From: Nolan, Chris <Chris.Nolan@lancashire.gov.uk>
Sent: 28 September 2017 15:02
To: Adam Birkett; planning
Cc: LHS Customer Service
Subject: D3.2017.0853 - Laneside, Sawley Rd, Chatburn

Planning Application No: 3/2017/0853
Grid Ref: 377321 445188
Proposal: Conversion of garage into family accommodation
Location: Laneside Sawley Road Chatburn Clitheroe BB7 4LD

OUTLINE PROPOSAL FOR ADDITIONAL ACCOMMODATION  
 AT LANESIDE, SAKLEY ROAD, CHATBURN, BB7 4LD

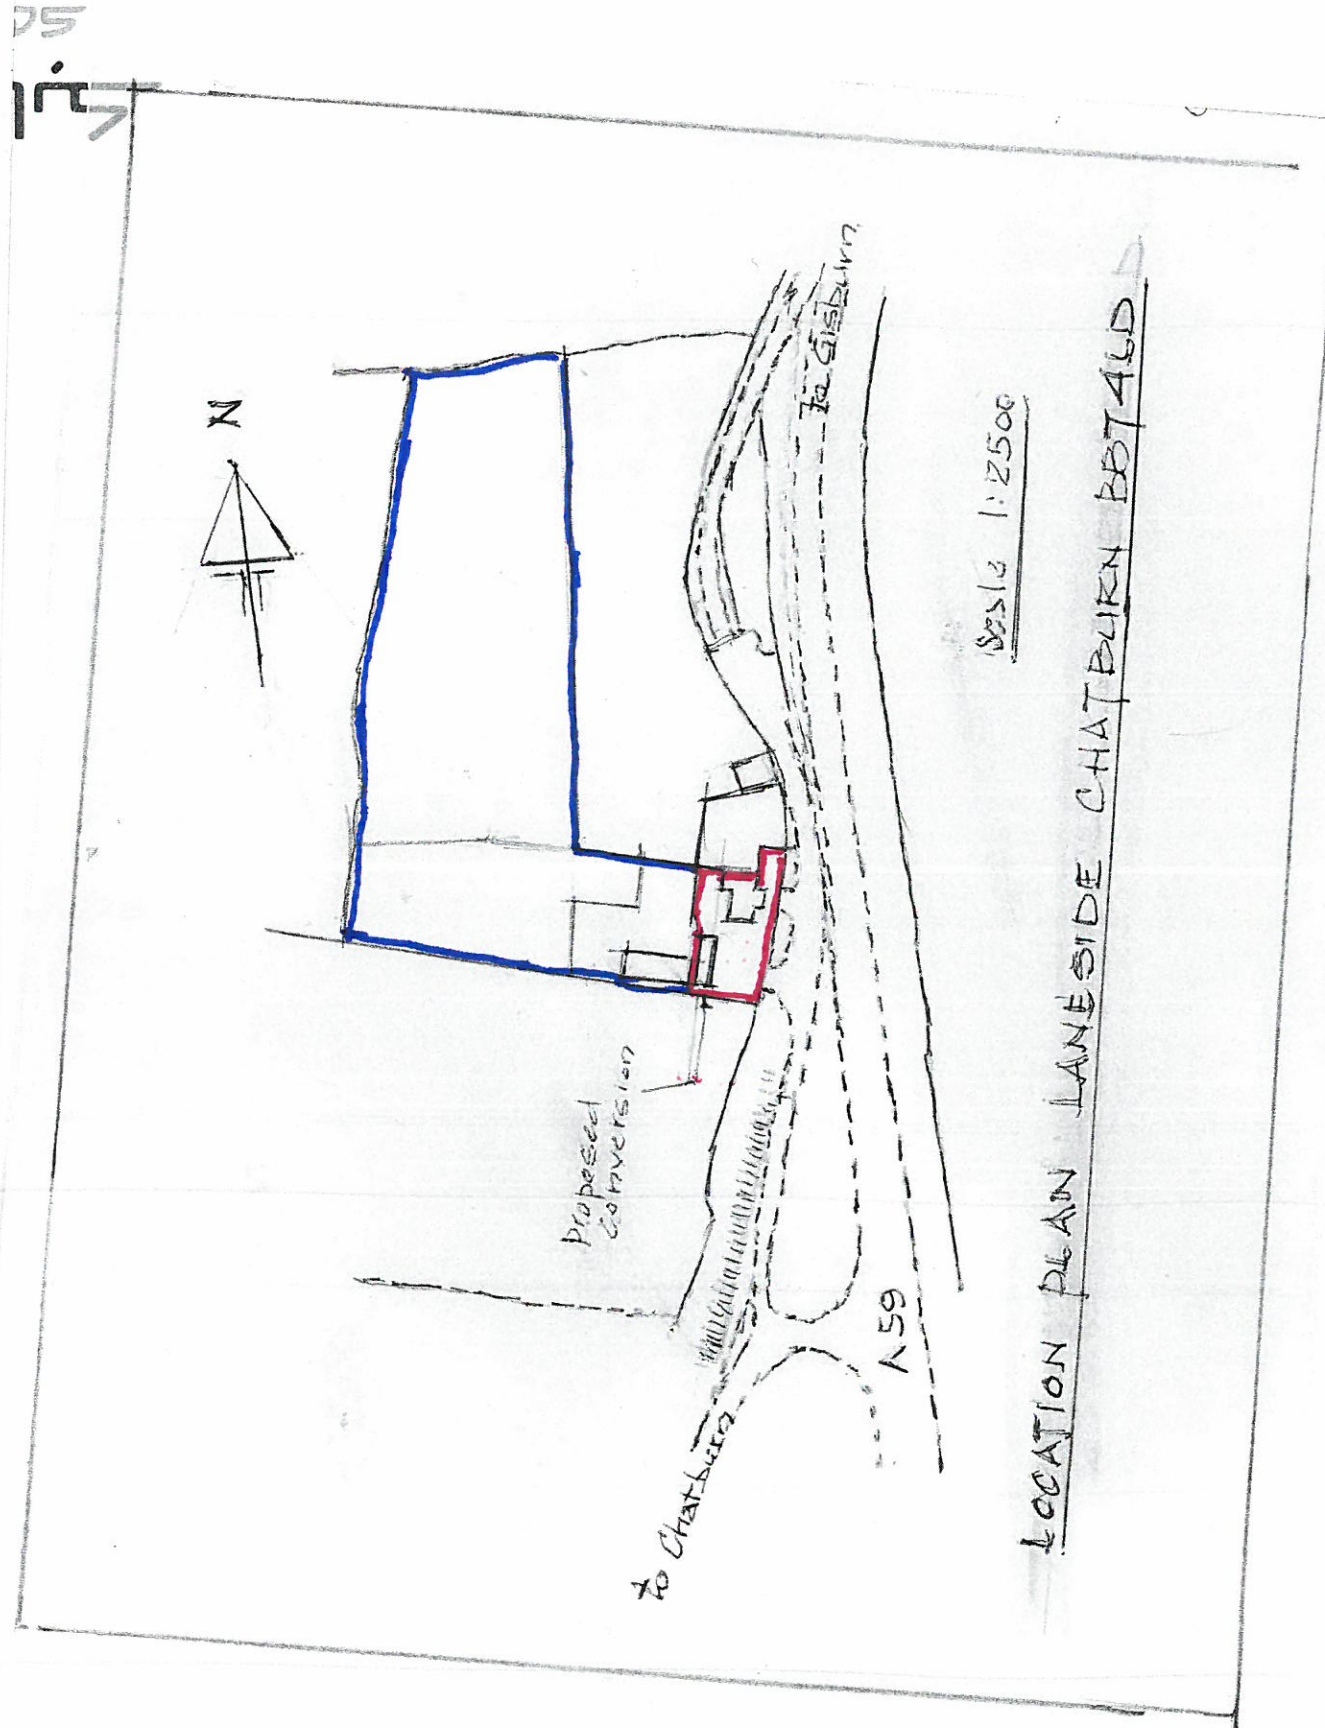
With regard to the above application I would not raise objections on highway grounds as there is plenty of land at the address to allow parking for both the existing home and the new dwelling that is to be formed from the present garage facility. This said, it is important that the parking is legally defined for each property so that if the dwelling is sublet or sold on completion or at any time in the future this matter is correctly managed. The new dwelling having 2 bedrooms will need a minimum of two parking spaces with sufficient space for each vehicle to enter and leave the site in forward gears. Similarly parking spaces will need to be defined for the main building. The number of spaces for the main building will depend on the number of bedrooms in the property. For 1 bedroom 1 parking space, 2 or 3 bedrooms 2 parking spaces and for 4 or more bedrooms 3 parking spaces will be required. I would be looking for plans to be provided in a suitable scale to indicate that this provision is met. It is also important that the parking and turning manoeuvres are possible and independent of each property. That is the residents of one property are not reliant on residents of the other to be able to access and turn their cars.

1. As a separate two bedroom dwelling within the site of the Laneside property, Sawley Road, Chatburn the property will have two allotted parking places and this provision will be included in any tenancy or sale agreement that results from the development. The parking places will be sited in such a positions that they can be used at any time without depending on other vehicles being moved. Reason: The property will need to be treated as a separate dwelling with its own parking requirements.

2. The parking needs for the existing home at Laneside, Sawley Road, Chatburn will have allotted parking spaces that will be sited in such a positions that they can be used at any time without depending on other vehicles being moved. Reason: The property will need to be treated as a separate dwelling with its own parking requirements.

3. Both properties will have right of access and egress between the highway and their allotted parking and turning areas and that this should be included in any tenancy or sale agreement that results from the development. Reason: to ensure that the parking requirements for each dwelling is maintained in perpetuity.

4. The layout of the development shall include provisions to enable vehicles to enter and leave the highway in forward gear and such provisions shall be laid out in accordance with the approved plan and the vehicular turning space shall be laid out and be available for use before the development is brought into use and maintained thereafter. Reason: Vehicles reversing to and from the highway are a hazard to other road users.
